# RFS

Your reference: SSD-70748466  
Our reference: DA20250726002963-Response to Submissions-1

**State Significant Development – Response to Submissions – Residential Subdivision/Masterplan  
Response to Submissions - Huntlee New Town - Stage 2 (SSD-70748466), (none)**

FIGURE 21: BAL MAP (SHEET 3)

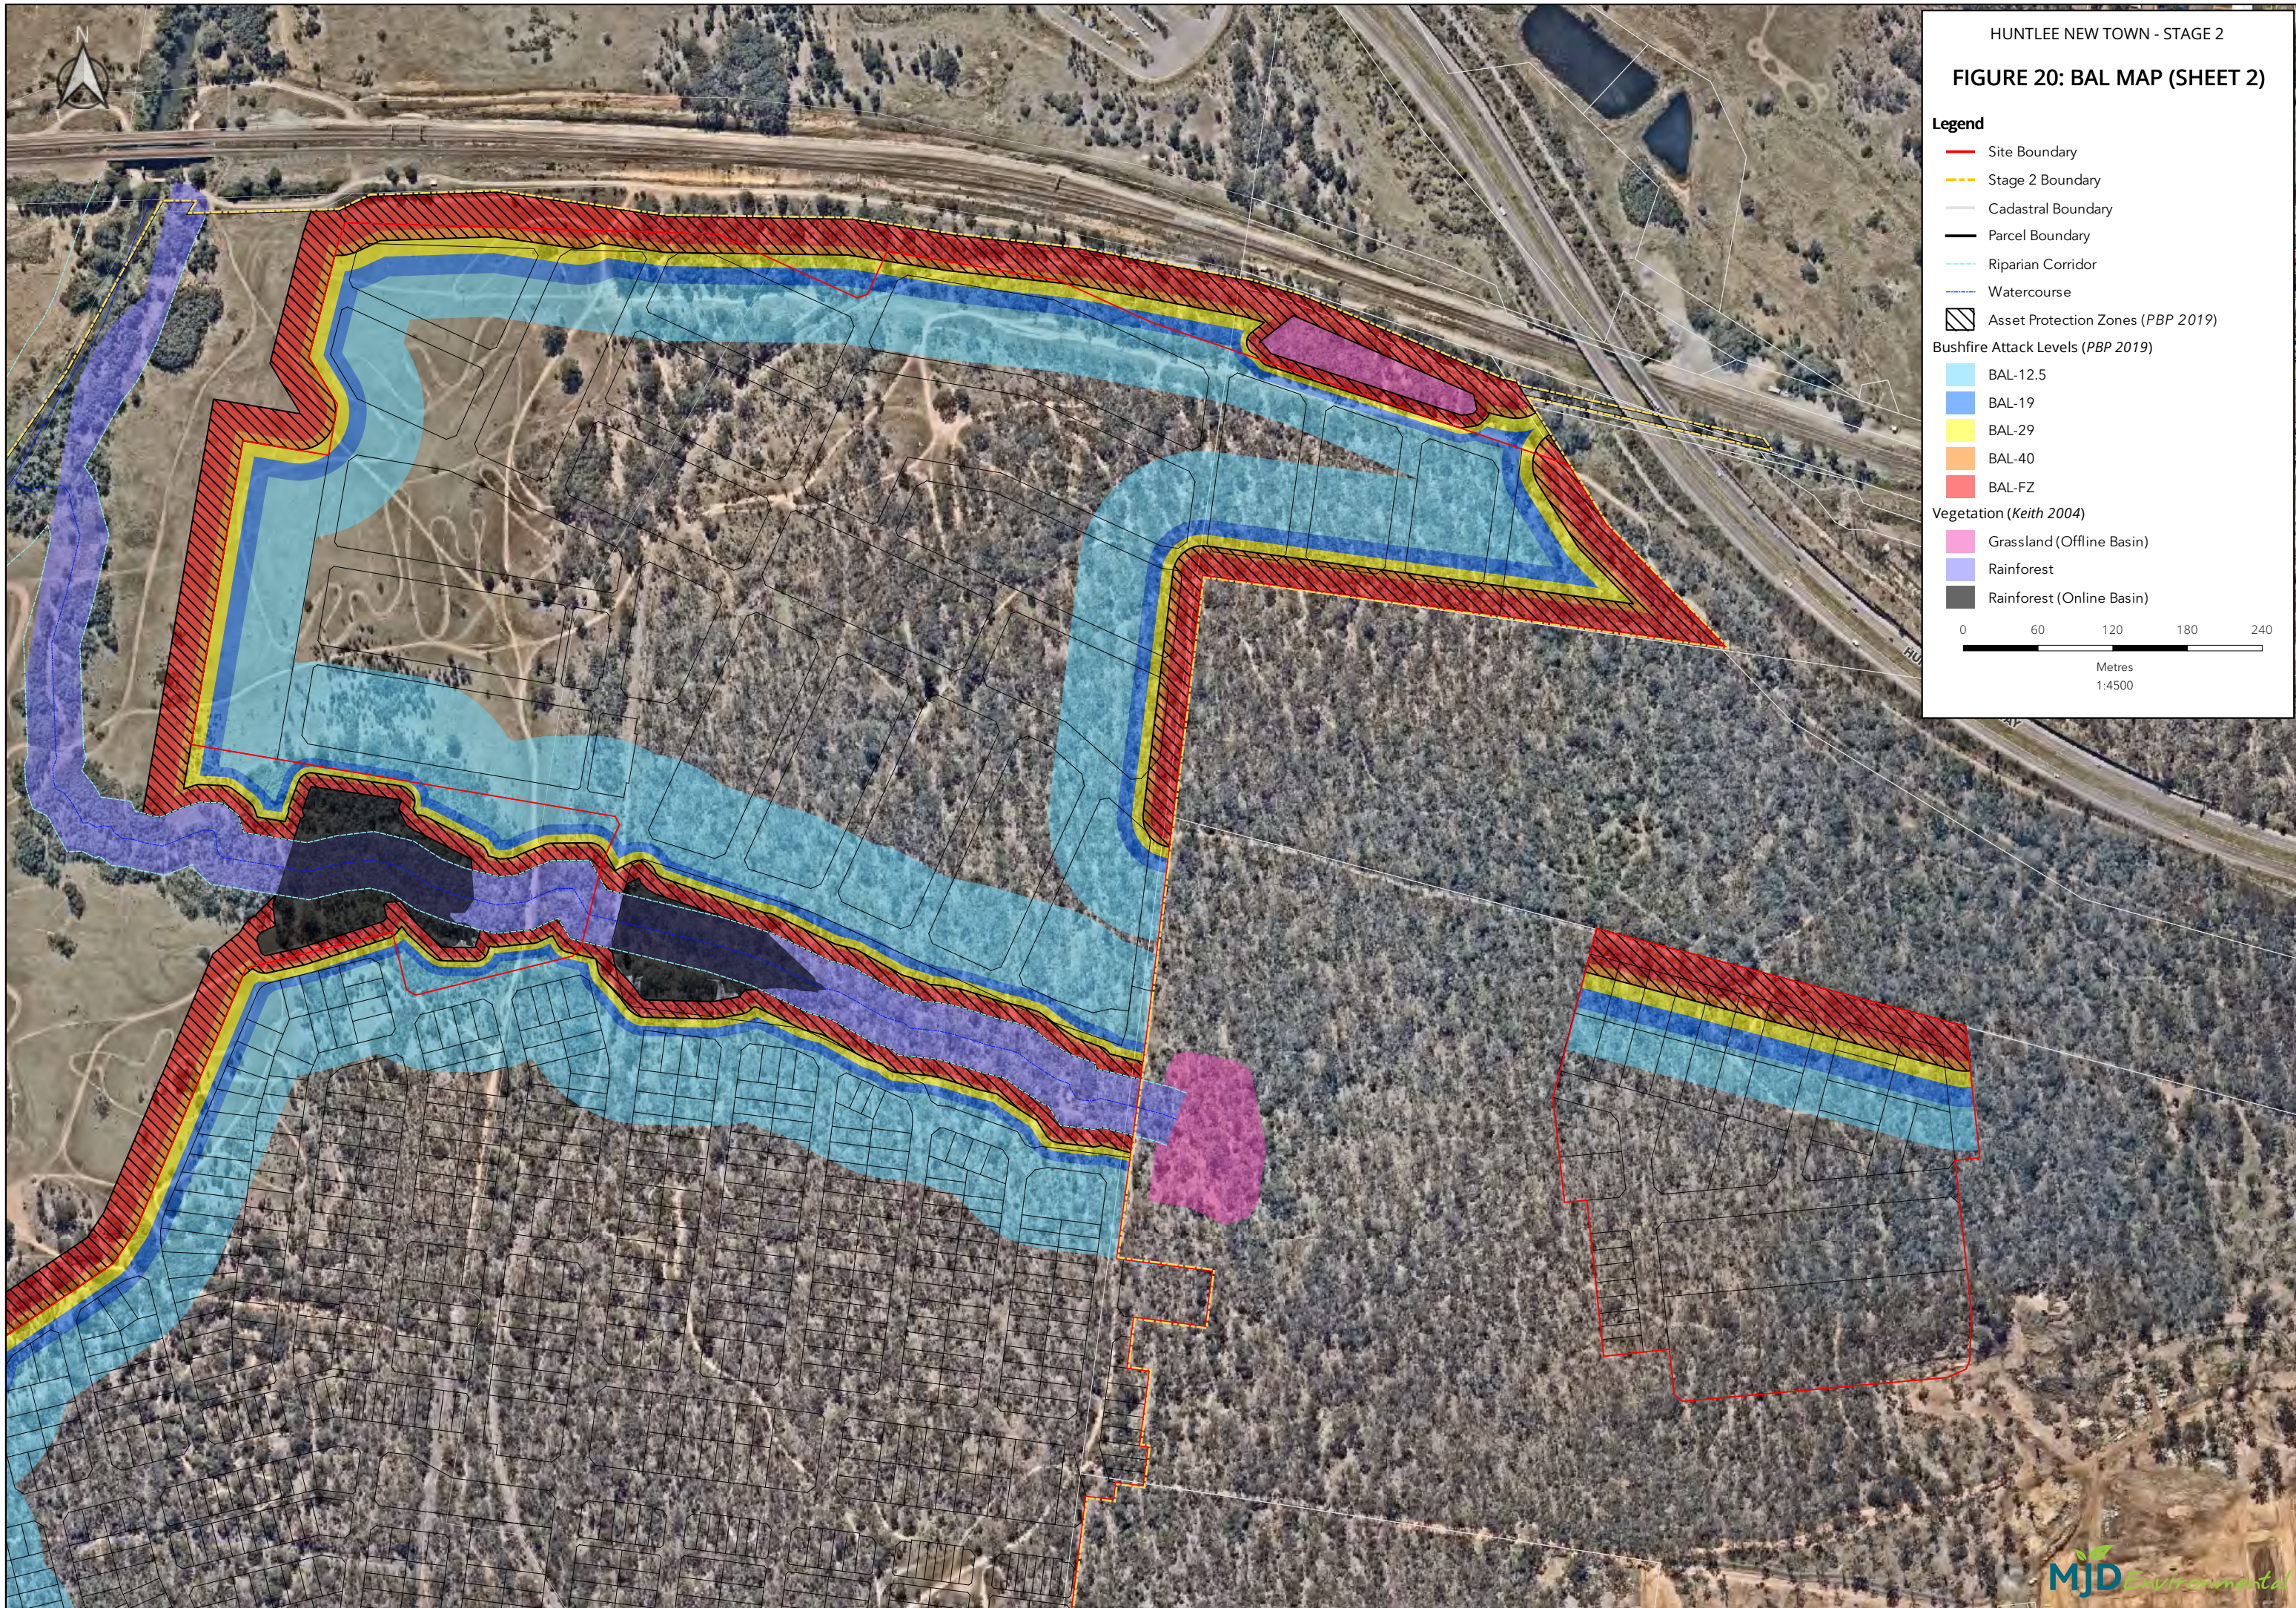
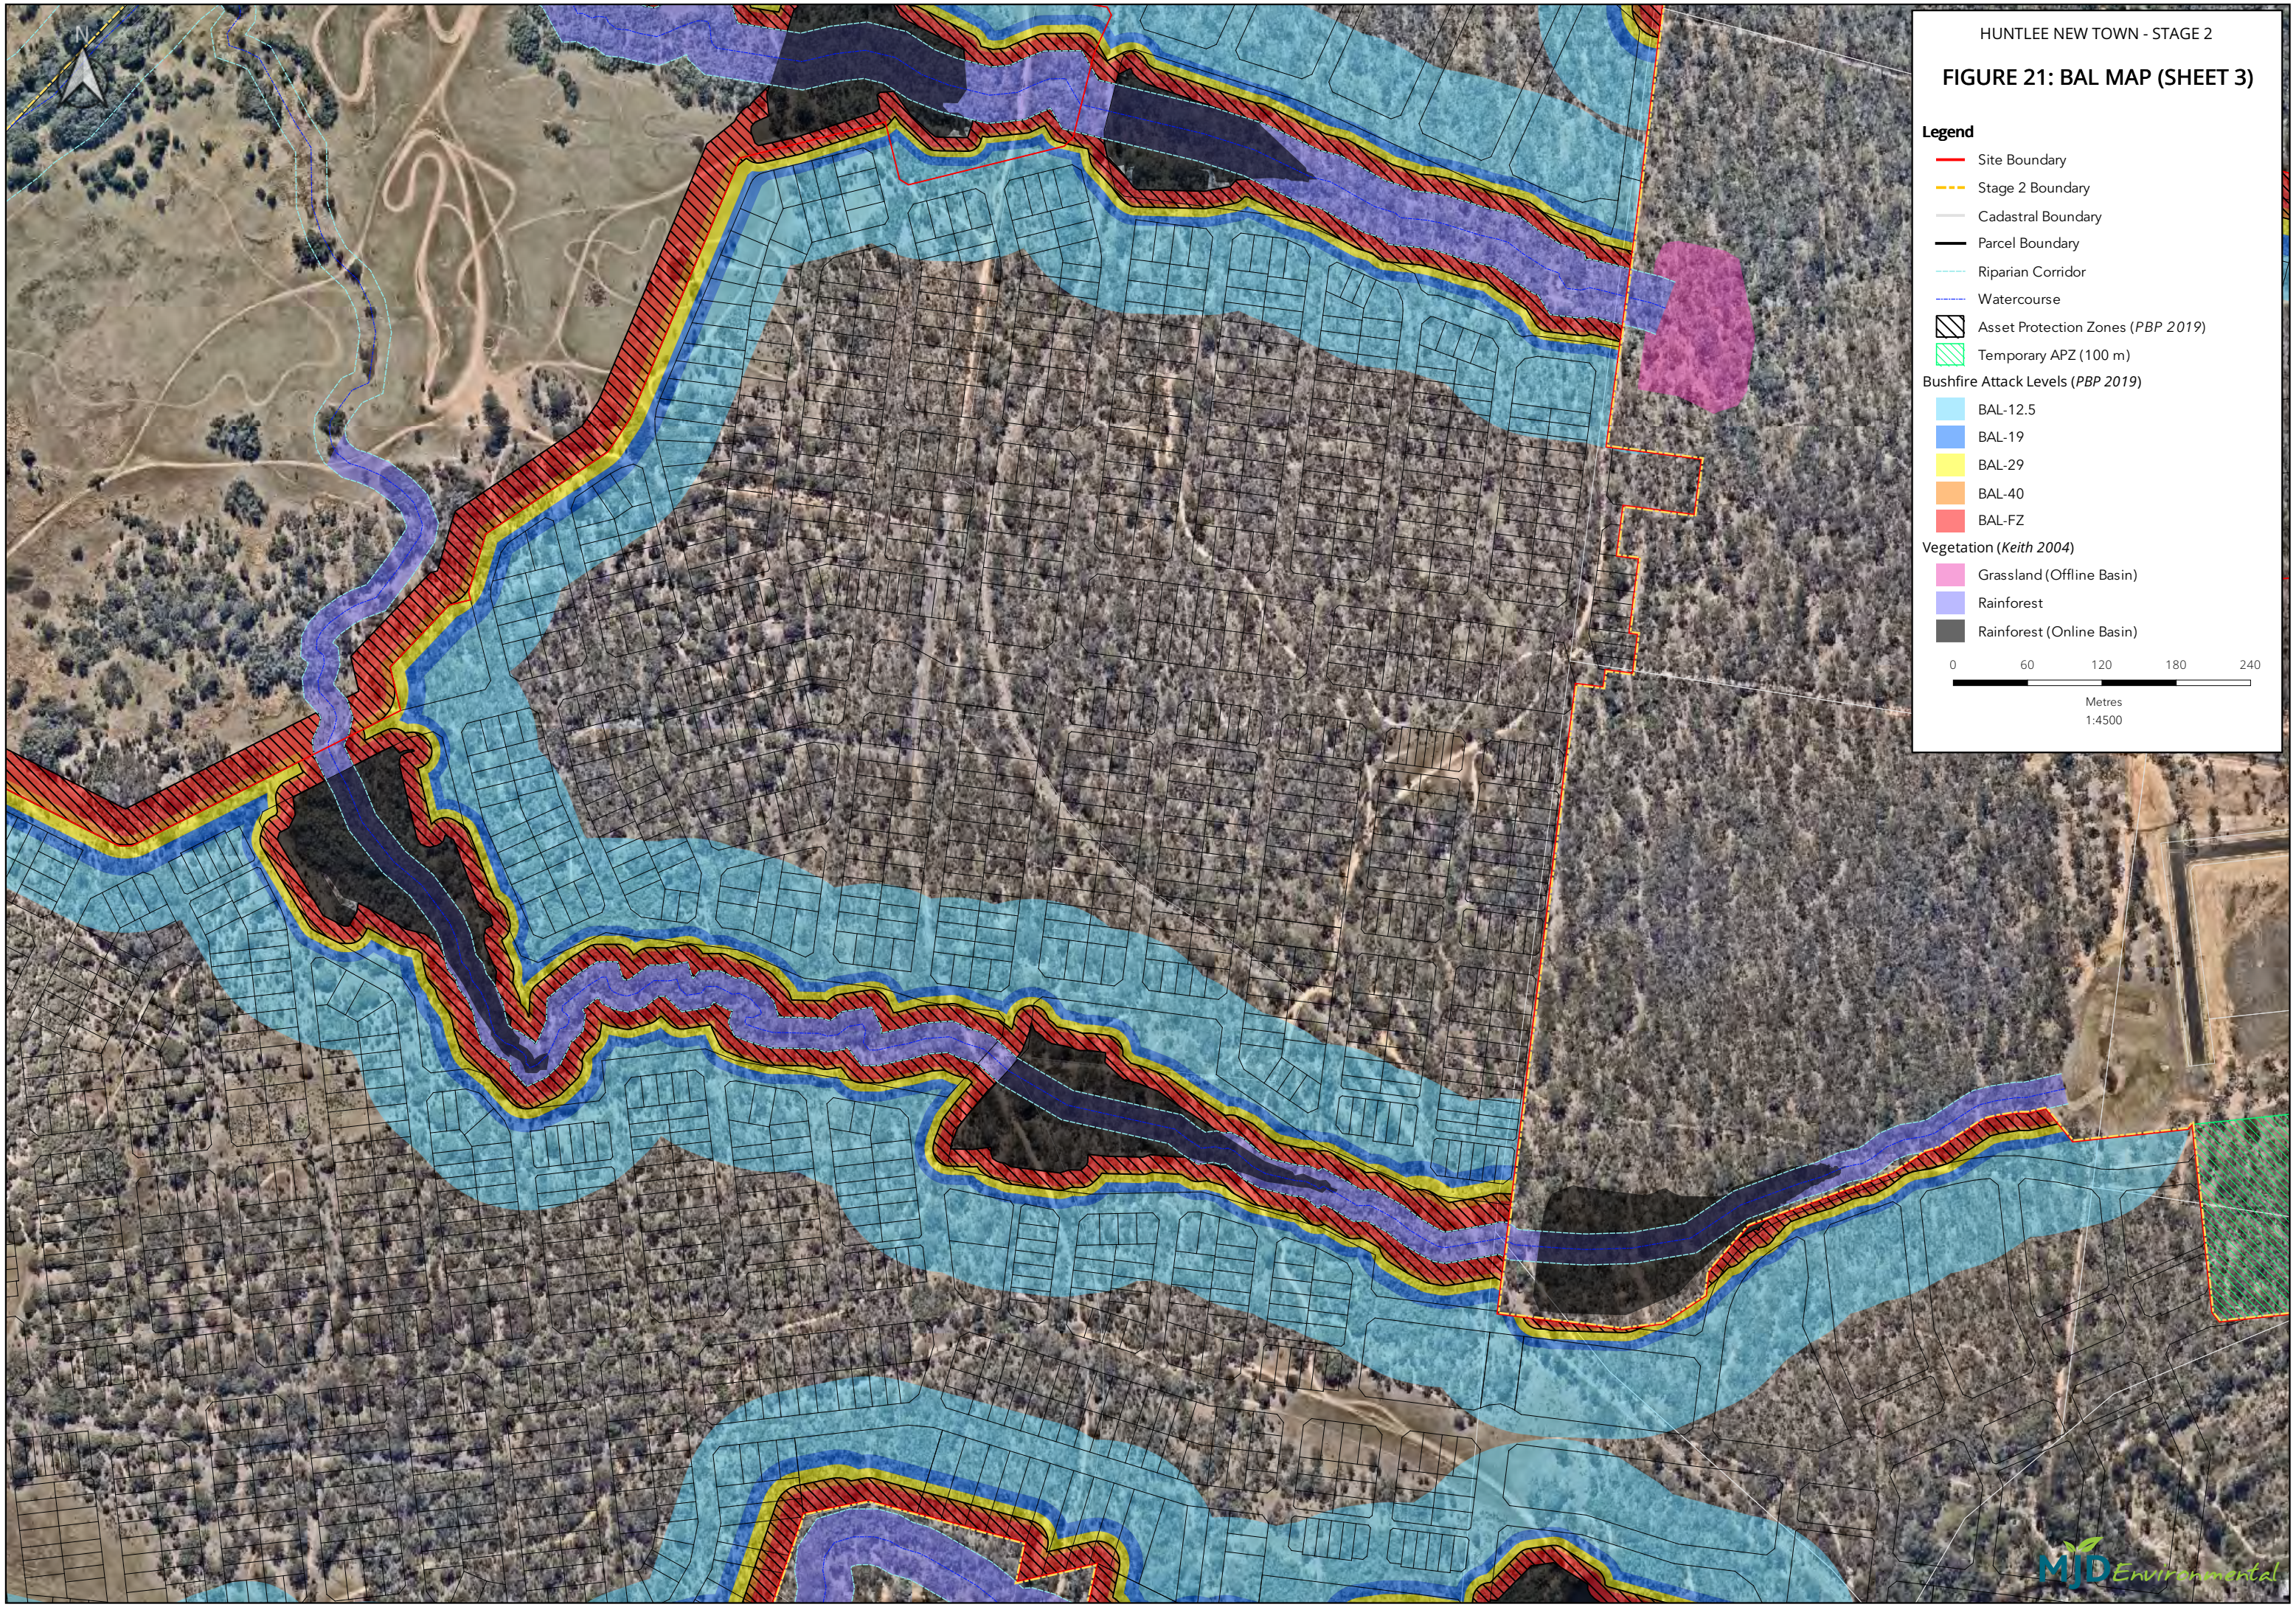
3. A bush fire attack level (BAL) Table must be prepared with regard to the comments above, with a BAL Plan identifying the lot numbers and BAL ratings applicable to future dwellings on lots within the subdivision of Village 2. The BAL Plan provided in Figures 20 to 25 in the bush fire report prepared by MJD Environmental (dated 11/06/2025, V.4, referenced Z:\16015 - Huntlee, Branxton) cannot be relied upon for future development as there is insufficient information provided in relation to establishment of APZs offsite and vegetation management of drainage basins.
